CITY OF ALBUQUERQUE

November 16, 2018

RE: **13424 Cedarbrook Ave NE**
Grading and Drainage Plan
Engineer's Stamp Date: 11/5/18
Drainage File: F23D013

Based on the submittal received on 11/5/18, the grading and drainage plan cannot be approved until the following are corrected:

WALL DETAILS AT ALL PROPERTY BOUNDARIES

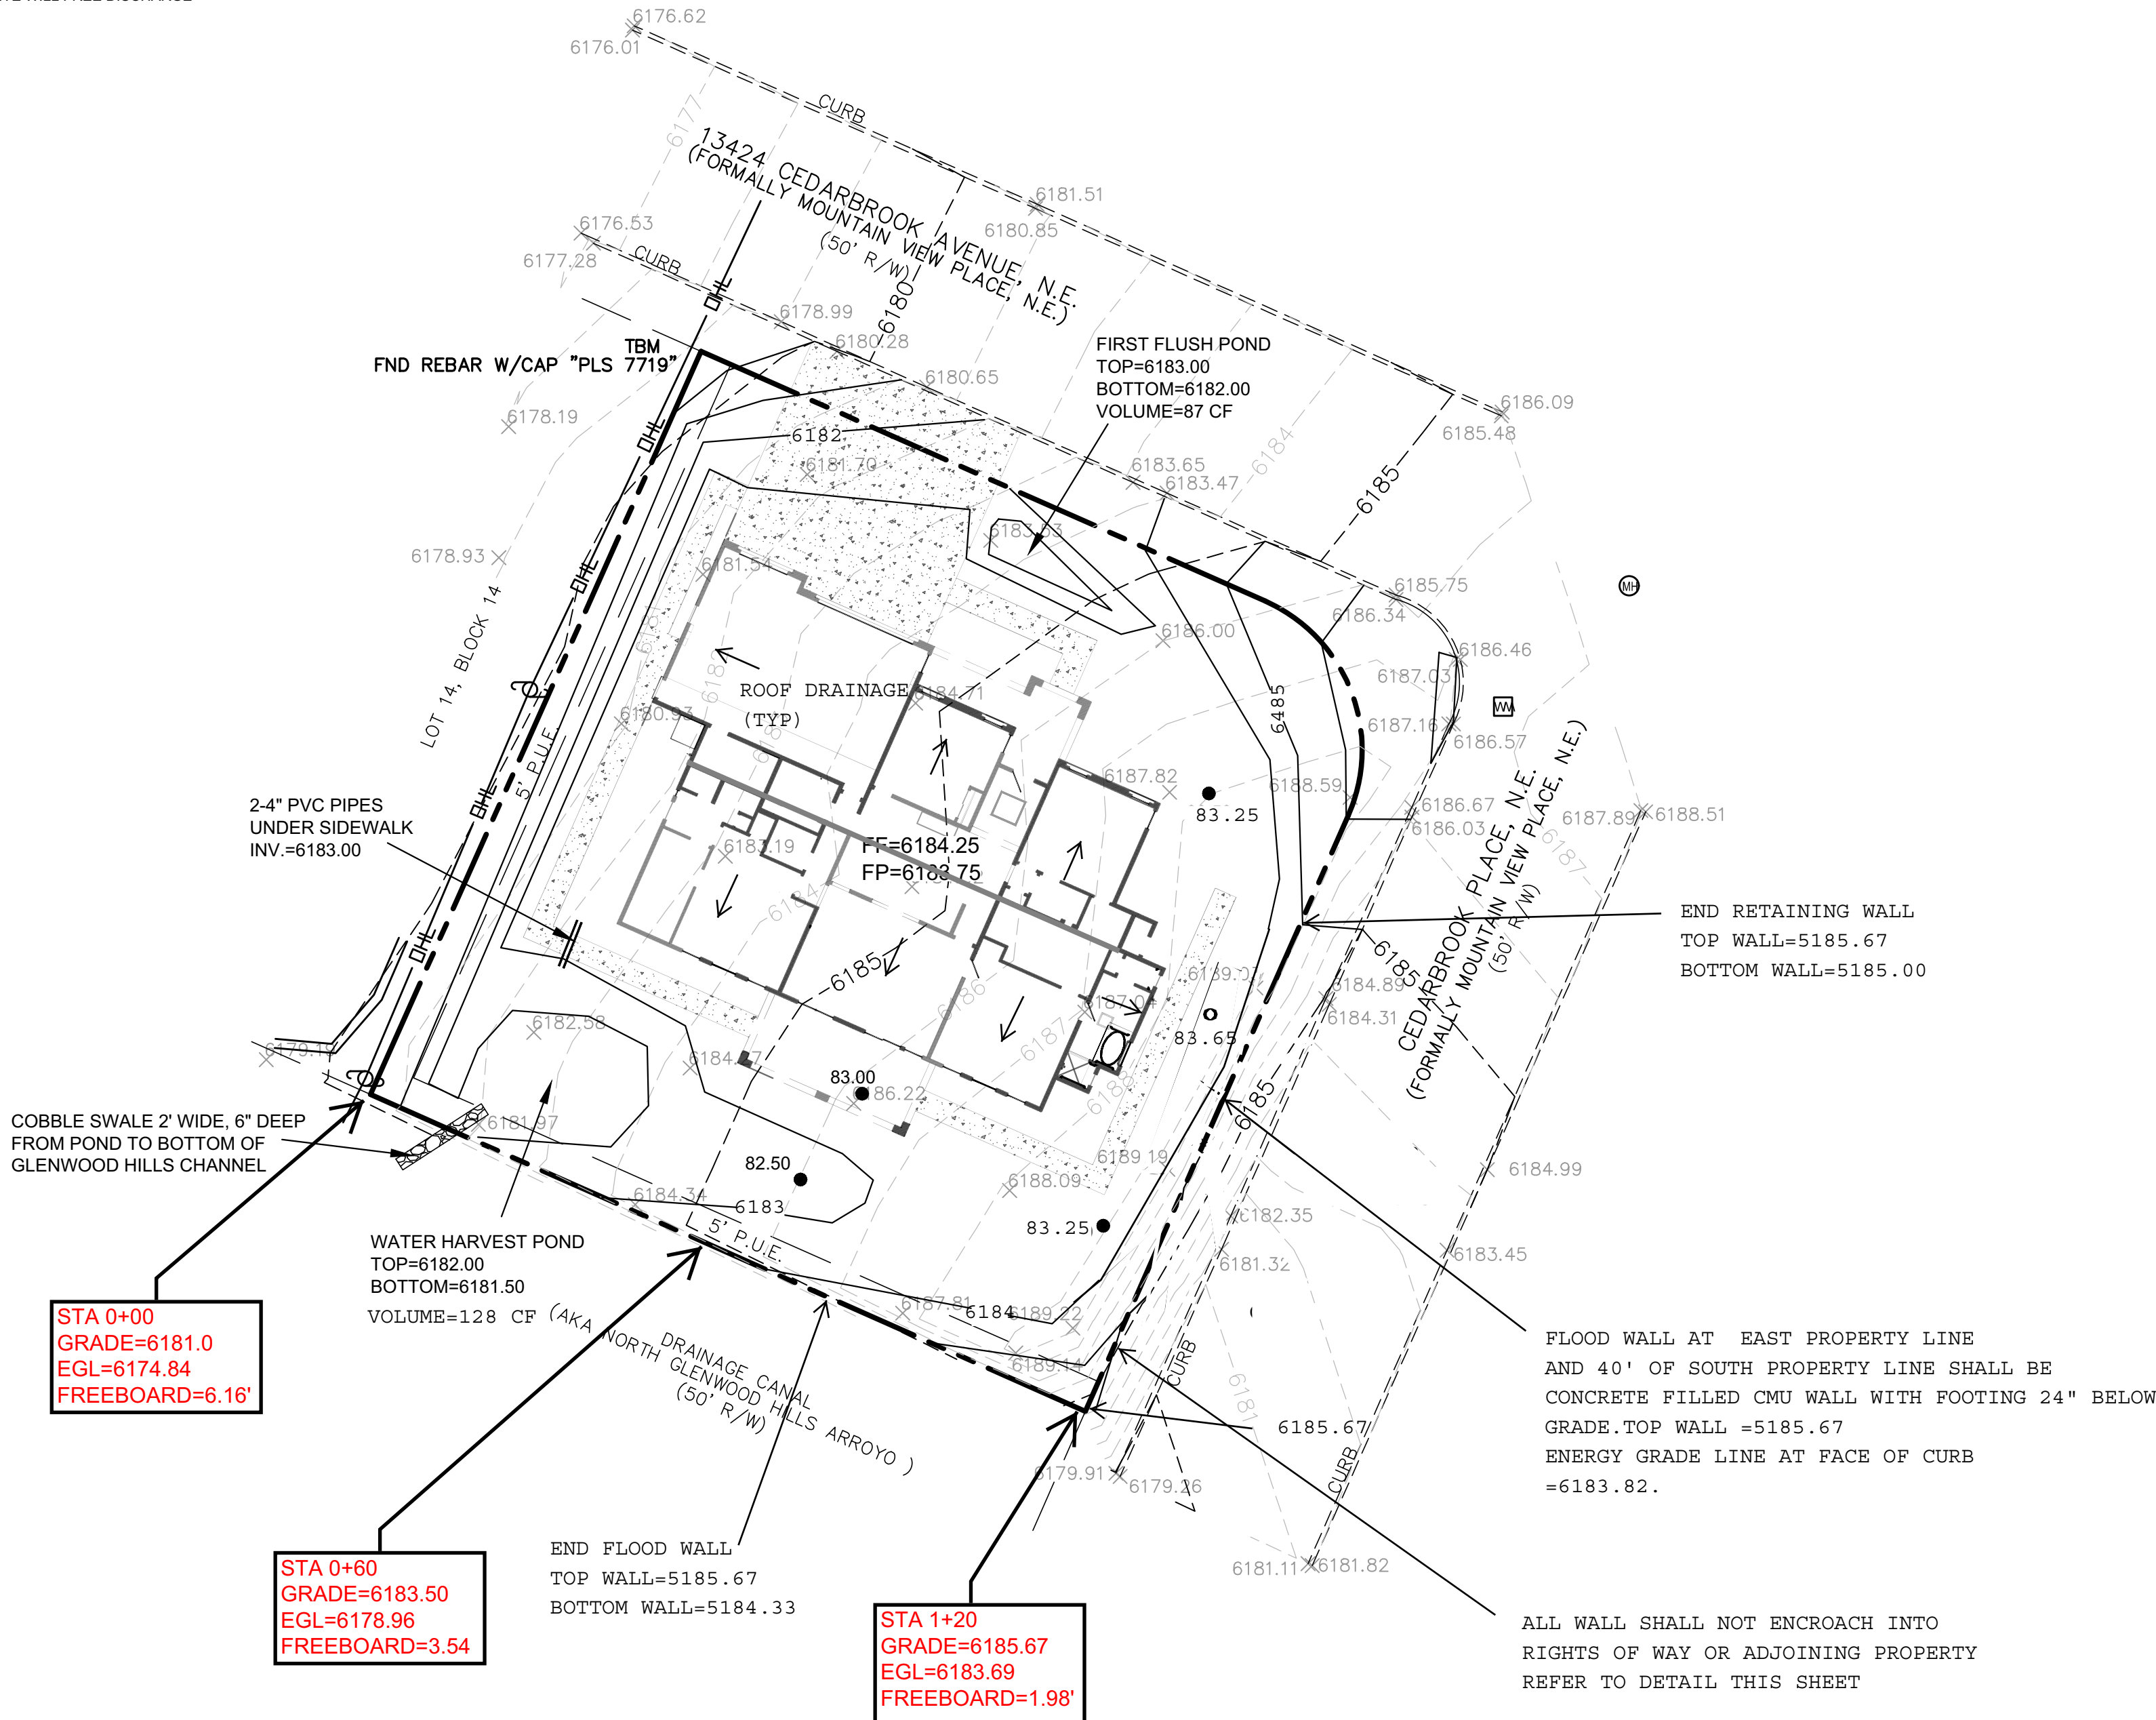
1. Show the freeboard wall in plan view and provide sections (east wall and south wall). Ensure the wall and footer do not encroach on either ROW. Any private encroachment into the public ROW will require a revocable permit.
